**WELWYN HATFIELD BOROUGH COUNCIL  
EXECUTIVE DIRECTOR - PLANNING, PUBLIC PROTECTION AND GOVERNANCE**

**DELEGATED APPLICATION**

**Application No:** 6/2016/1068/FULL  
**Location:** Barham Court, 80 Station Road, Cuffley, Potters Bar, EN6 4HY  
**Proposal:** Addition of A3 (Restaurant and Cafe) use alongside previously granted uses A1 (Retail), A2 (Financial and Professional Services) and B1 (Business) to the commercial unit to ground floor  
**Officer:** Mrs J Pagdin

**Recommendation:** Refused

DWG No. BEV 171 MK 001

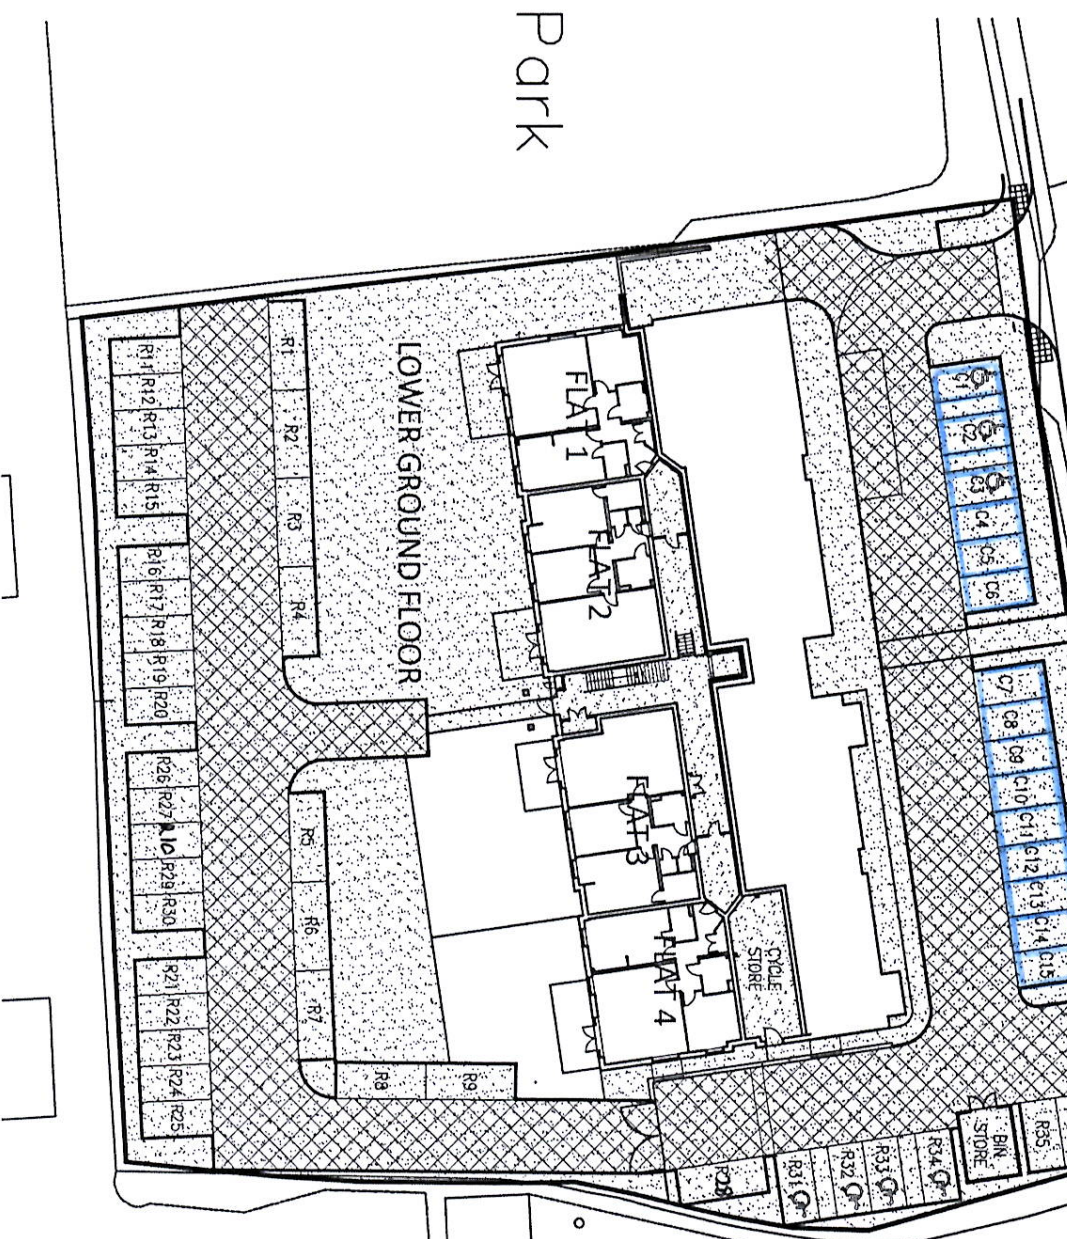
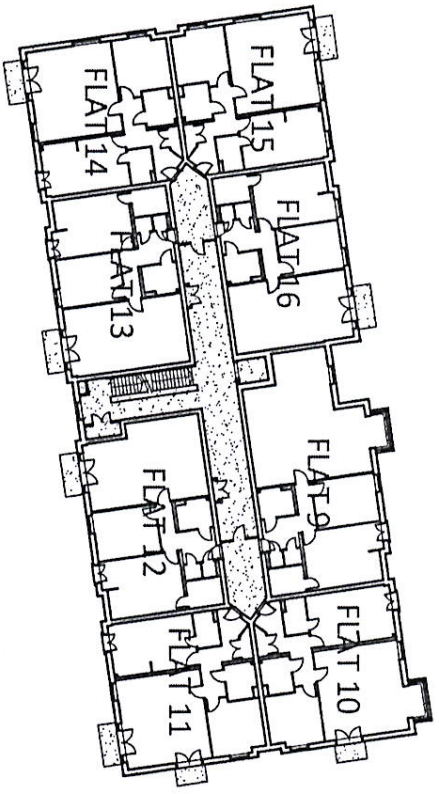
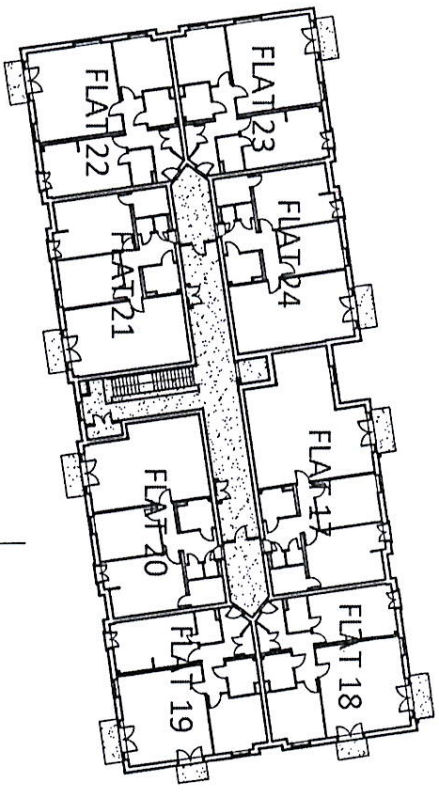
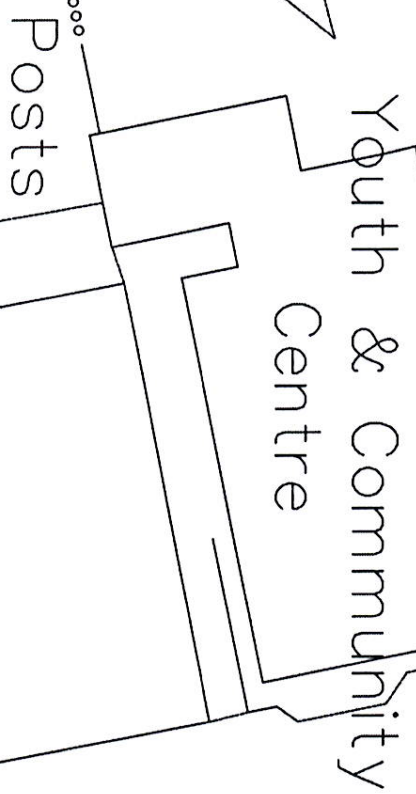
The car parking standards for A3 uses require customer and staff parking; customer parking at 1 space per 5sqm of dining area and staff at 3 spaces per employee. The dining area of 240sqm requires 48 parking spaces. The equivalent of 25 full time staff would require 19 spaces. The total parking requirement would be 67 spaces.

1. The proposed development would create a demand for car parking that would not be provided for within the application site and would, as a result, create significant overspill parking demand that would give rise to parking congestion on surrounding roads and create inconvenience to other road users and have an adverse impact on the living conditions enjoyed by occupiers of residential properties in the vicinity of the site. The proposal would, therefore, be contrary to Policies M14 and D5 of the Welwyn Hatfield District Plan 2005, Supplementary Planning Guidance - Car Parking Standards 2004 and the Interim Policy on Car Parking and Garage Sizes 2014.
